From: [Cattier, Sophie](#)
To: [East Anglia ONE North](#)
Cc: [Fletcher, Will](#); [Robinson, Joanne](#)
Subject: East Anglia ONE North Offshore Wind Farm - EN010077
Date: 02 November 2020 18:25:27
Attachments: [Historic England Written Reps EA1N Fin.pdf](#)

**APPLICATION BY EAST ANGLIA ONE NORTH LIMITED FOR AN ORDER
GRANTING DEVELOPMENT CONSENT FOR THE EAST ANGLIA ONE NORTH
OFFSHORE WIND FARM**

APPLICATION REF: EN010077 (EA1N) & EN010078 (EA2)

Figure: 29.37e
Viewpoint 5: Public Right of Way, near Moor Farm

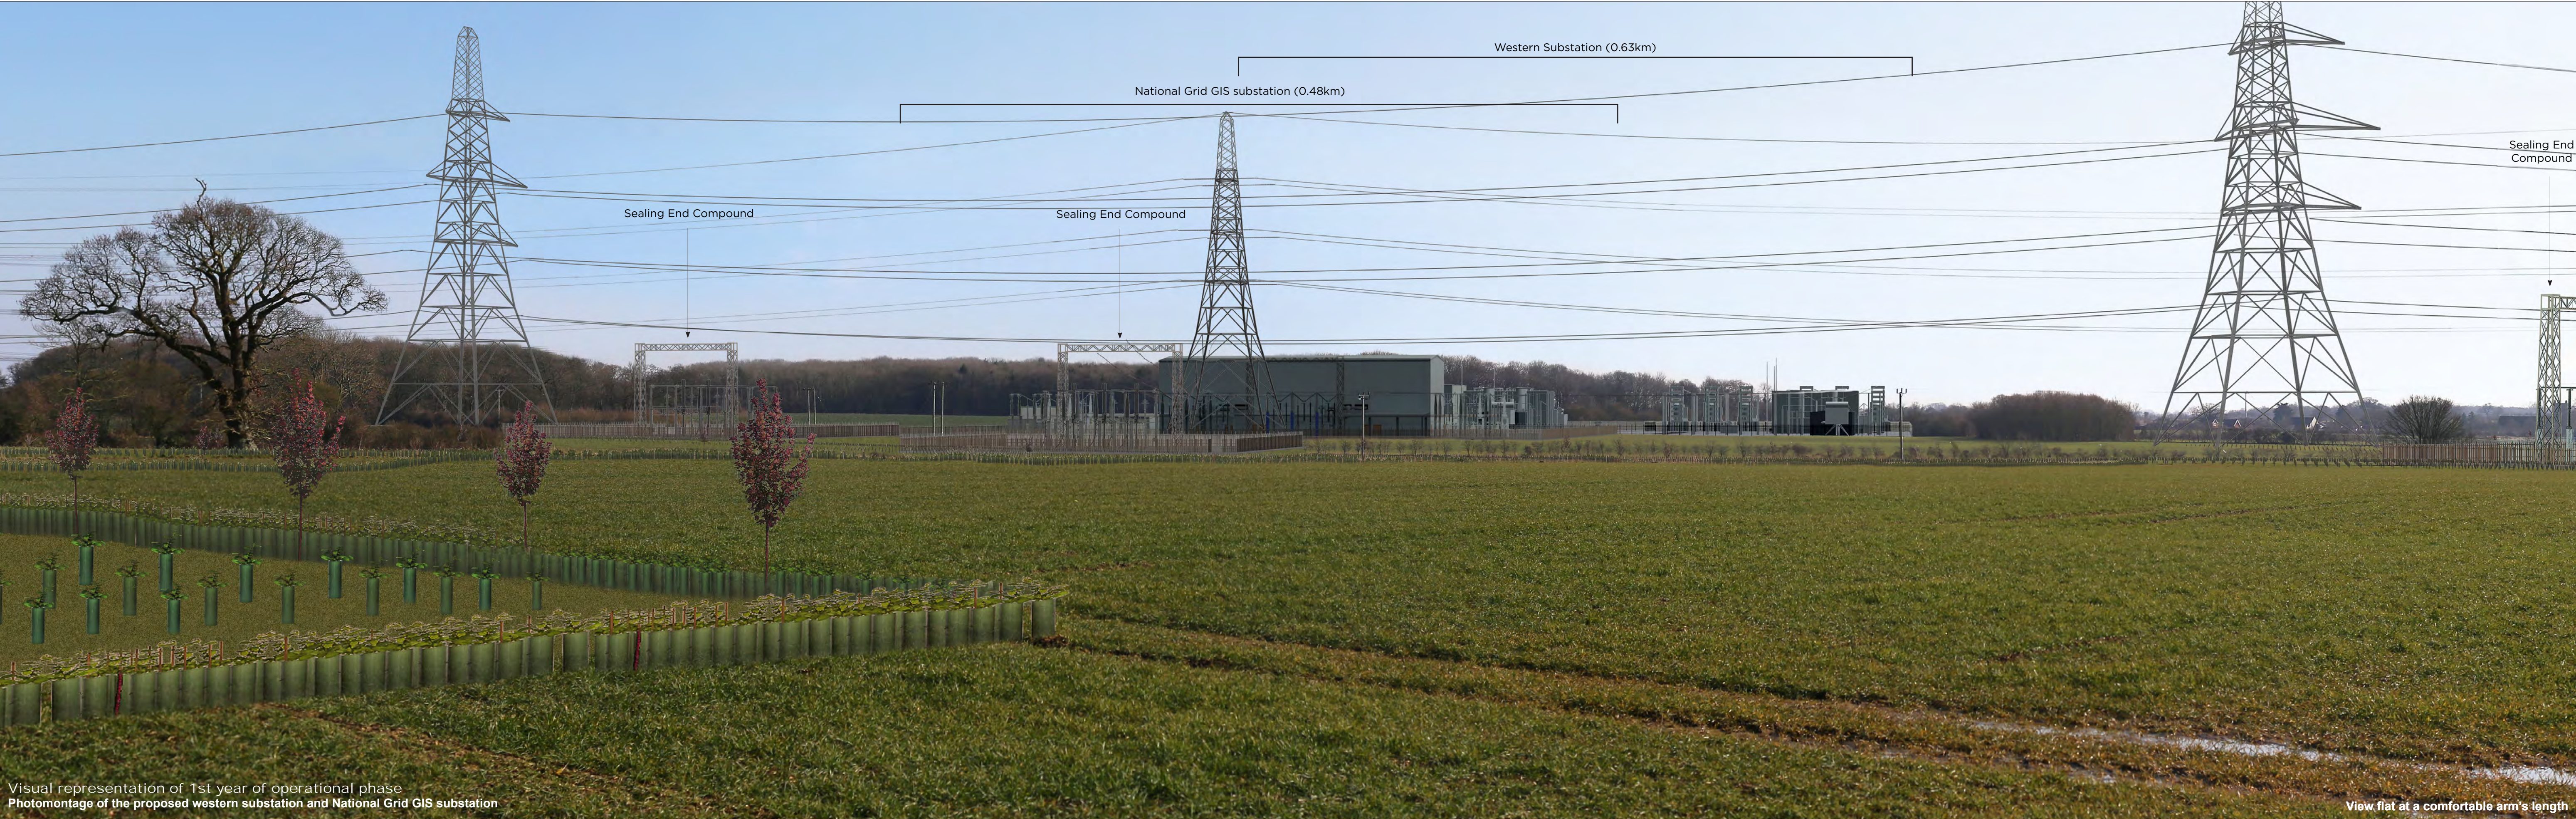
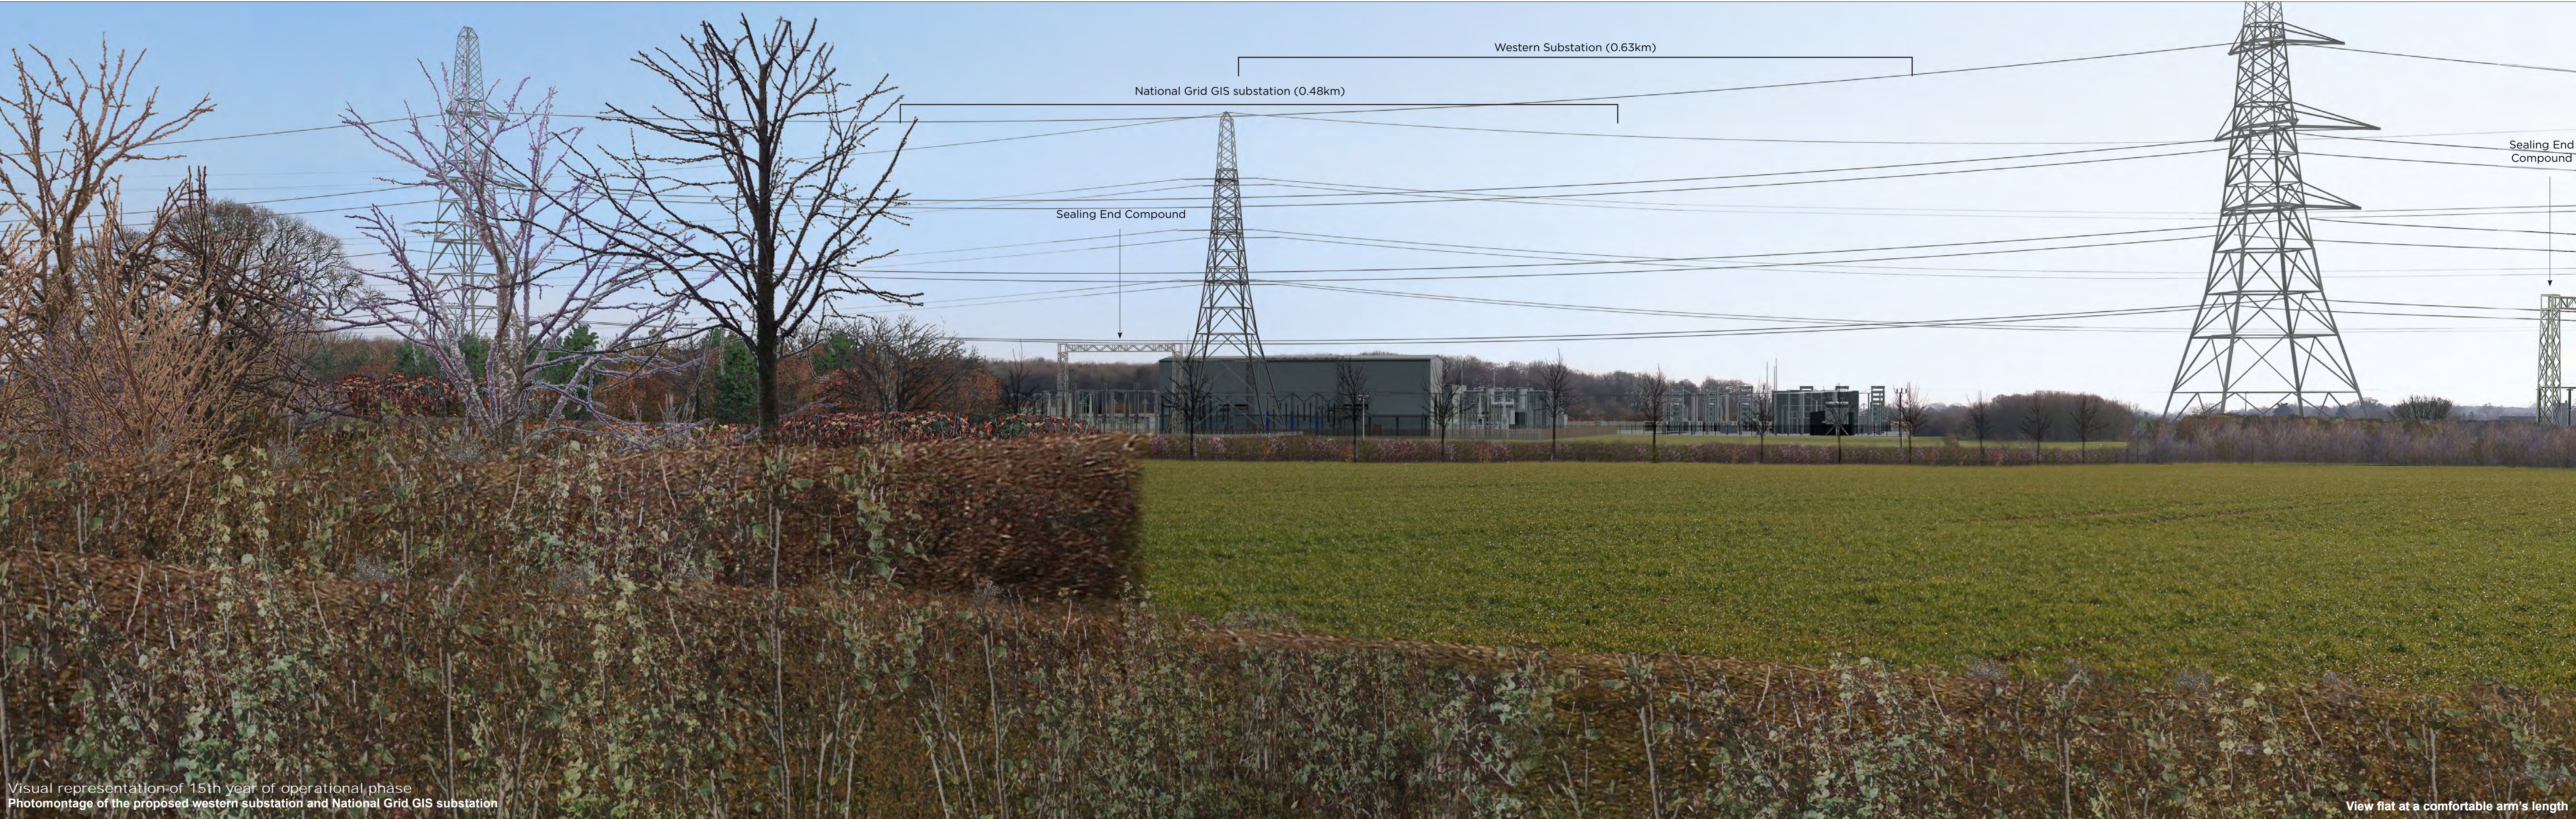
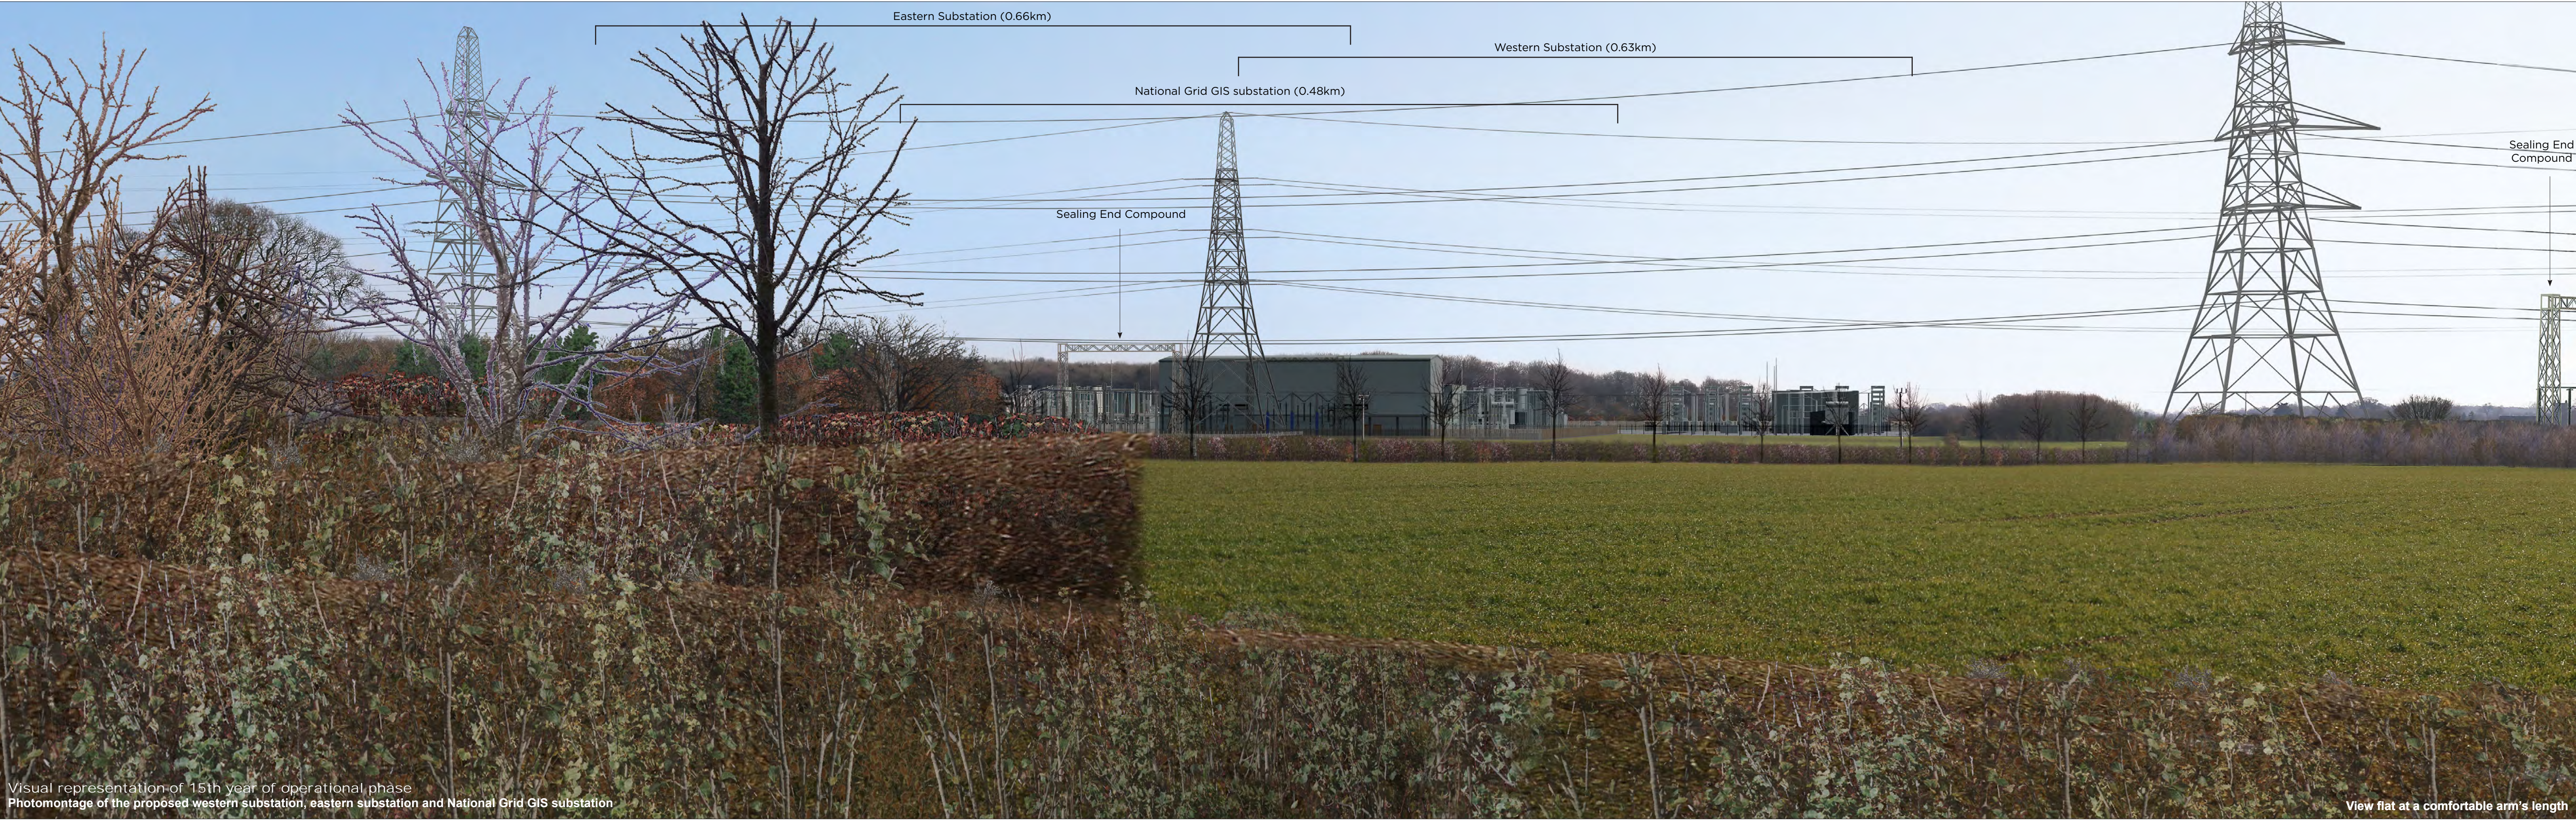
- 2.3.7. Viewpoint 5 is taken from the north of the proposed development site from the public right of way near Moor Farm (again also Grade II listed). From here the church is seen across a rural landscape. Although this is currently traversed by the existing power line, the lattice structure of the pylons and the height of the cables allow views through the line which sits above the height of the tree line and church tower. The development would stretch across much of this view. It would not obscure views of the church which lies to the west. However, it would erode the rural setting and appreciation of the church from the north and introduce a much larger modern structure which would detract from the church as a focal point. In views to the east of the viewpoint, the development would clearly obscure the view of the church. Parts of the national grid substation would rise above the treeline of the wood. After 15 years the strengthening of the hedge line in the foreground would screen much of the development excepting some of the taller parts. However, again it would characterise the experience of the church from the north.
